1363 Washington Avenue / Taco Bell - Final Traffic Comments

Jean – The following is a status update from my preliminary review and represents my final comments.

Not Approved for Construction  
Drawing Title  
**Layout & Materials**  
Drawing Number

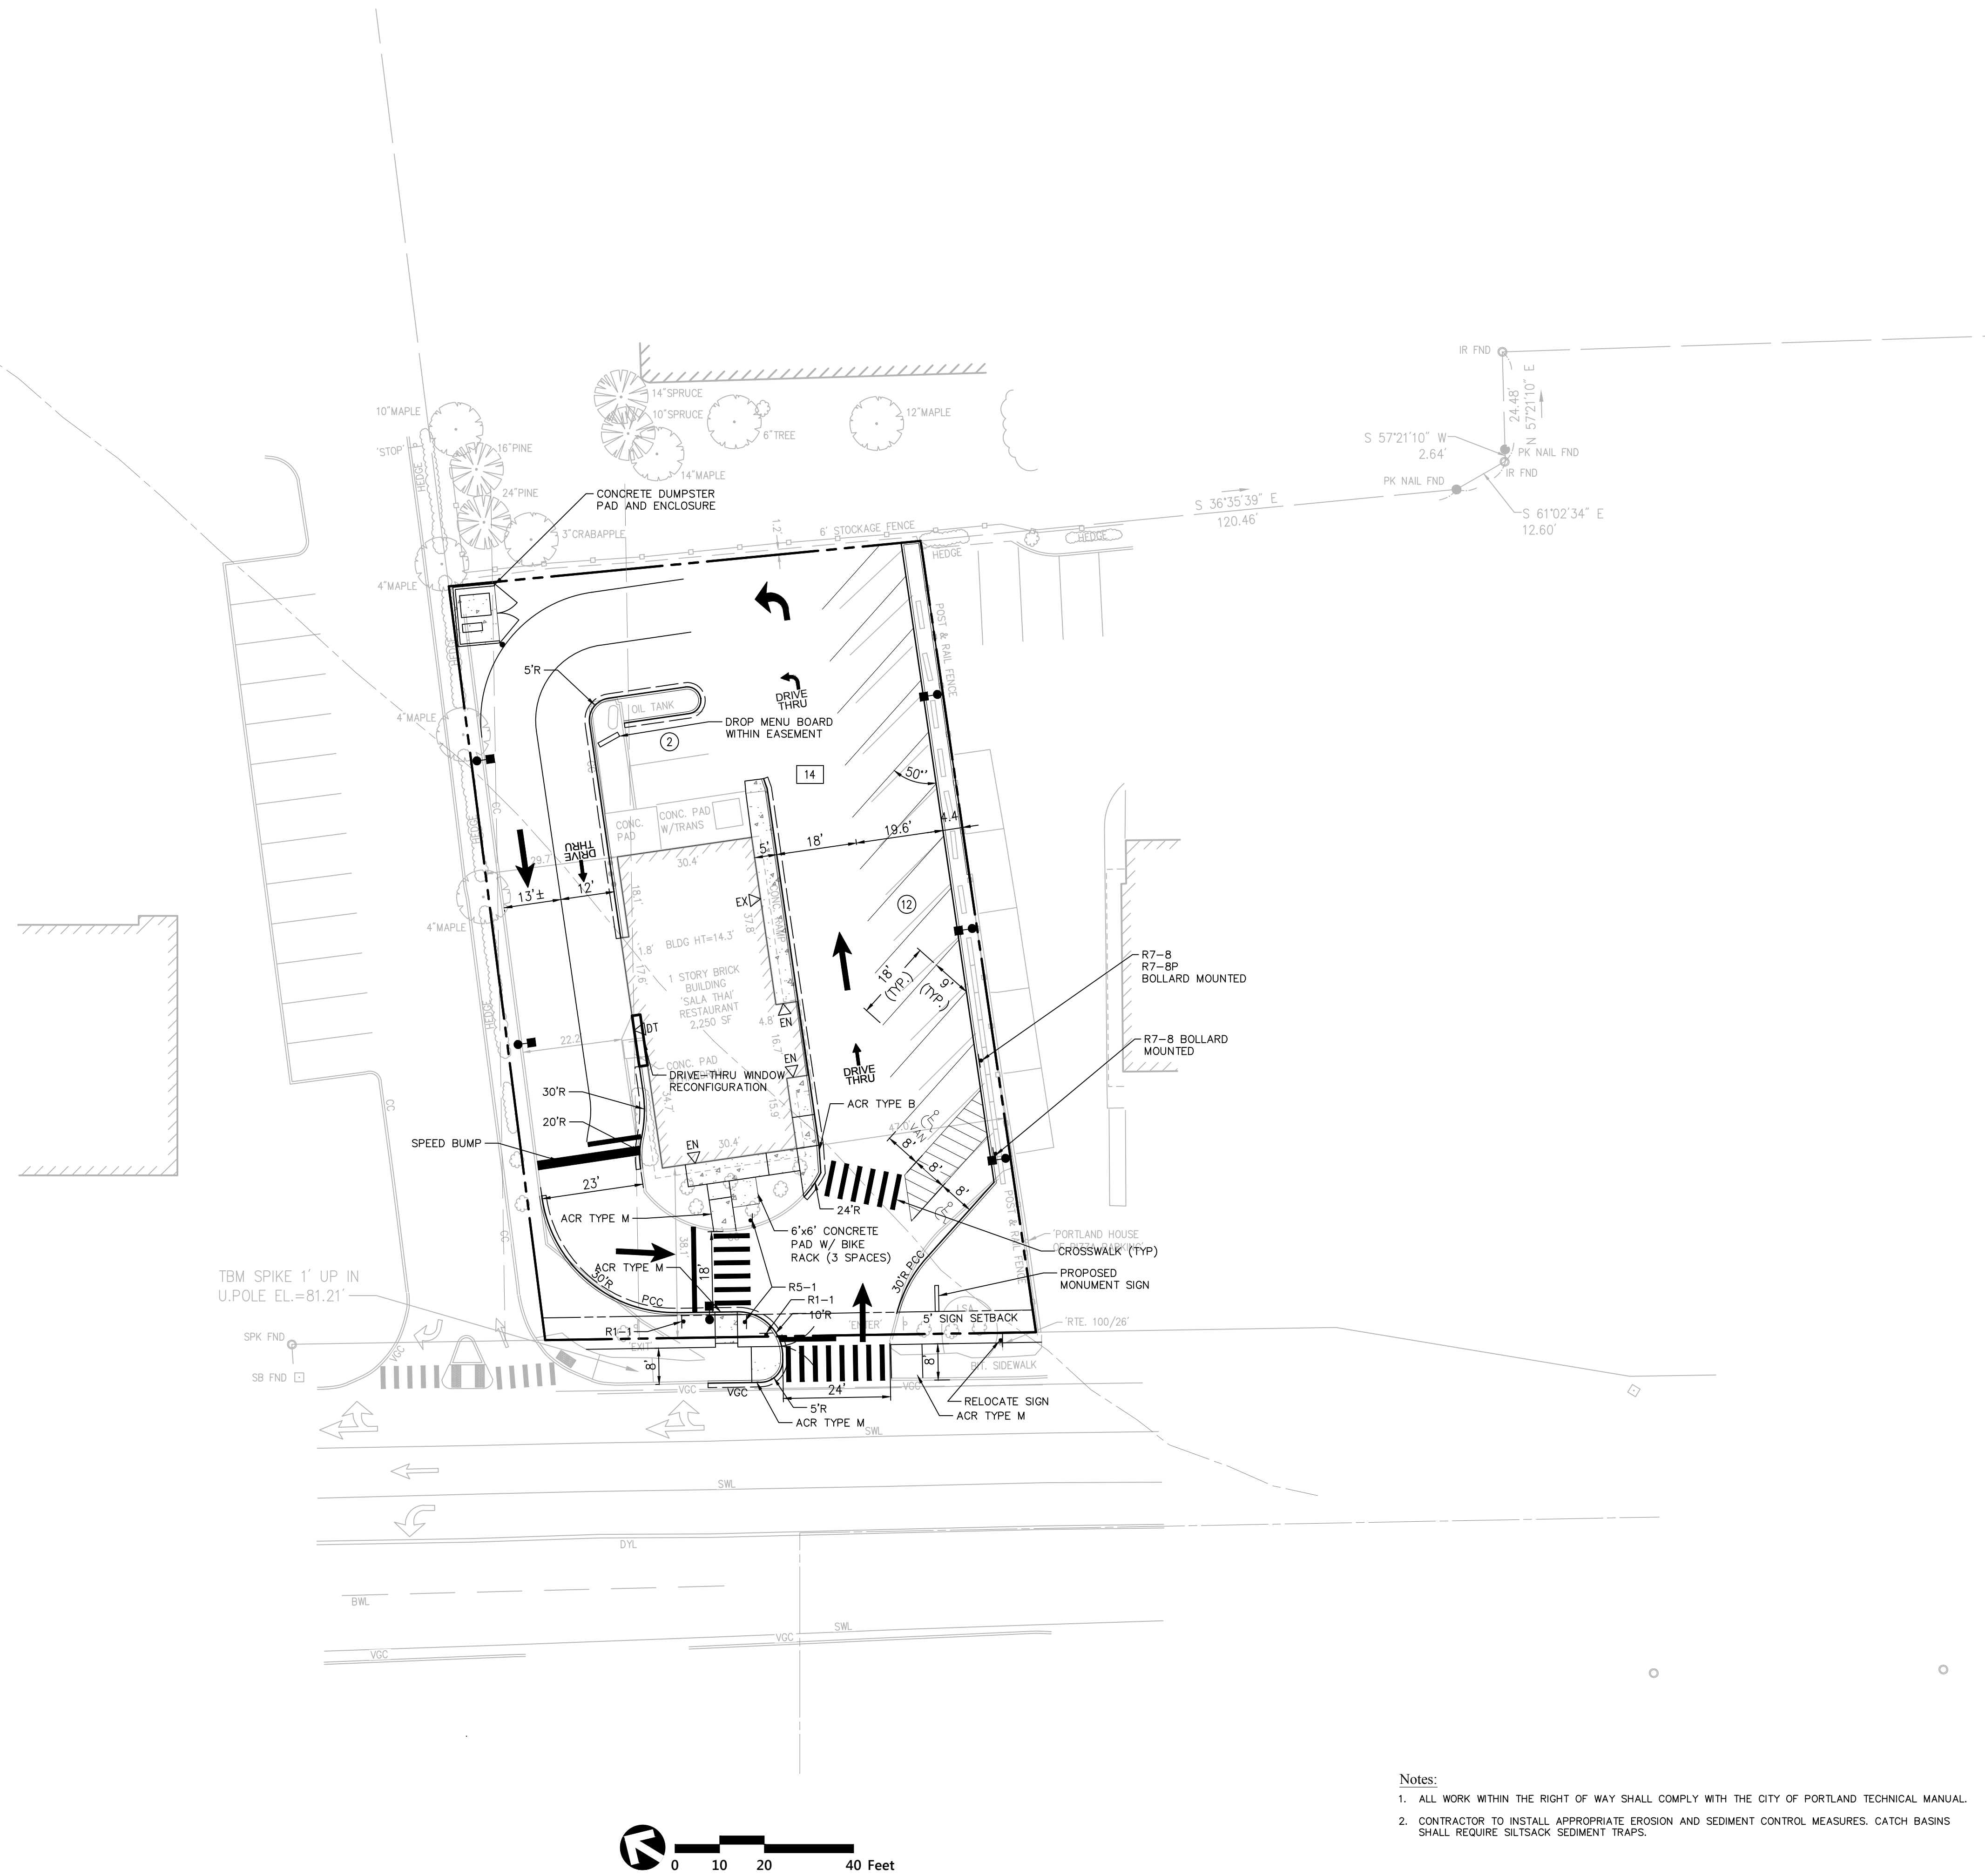
- The applicant should provide bike racks on-site that meet City standards.

- Sidewalk improvements along the property frontage on Washington Avenue shall be included. Two utility poles are located in the sidewalk and their location obstructs pedestrian accessibility. I would suggest the sidewalk be widened toward the site to accommodate a 5-foot clearance to the face of poles.

- The applicant should provide dimensions for all on-site parking lot elements and note whether City standards are met.

Status: Bike racks have been added and I have no further comment.

Status: The plans have been revised and I have no further comment.

Status: Acceptable dimensioning have been provided. I would also note that I find the changes to the angled parking alignment to be acceptable.
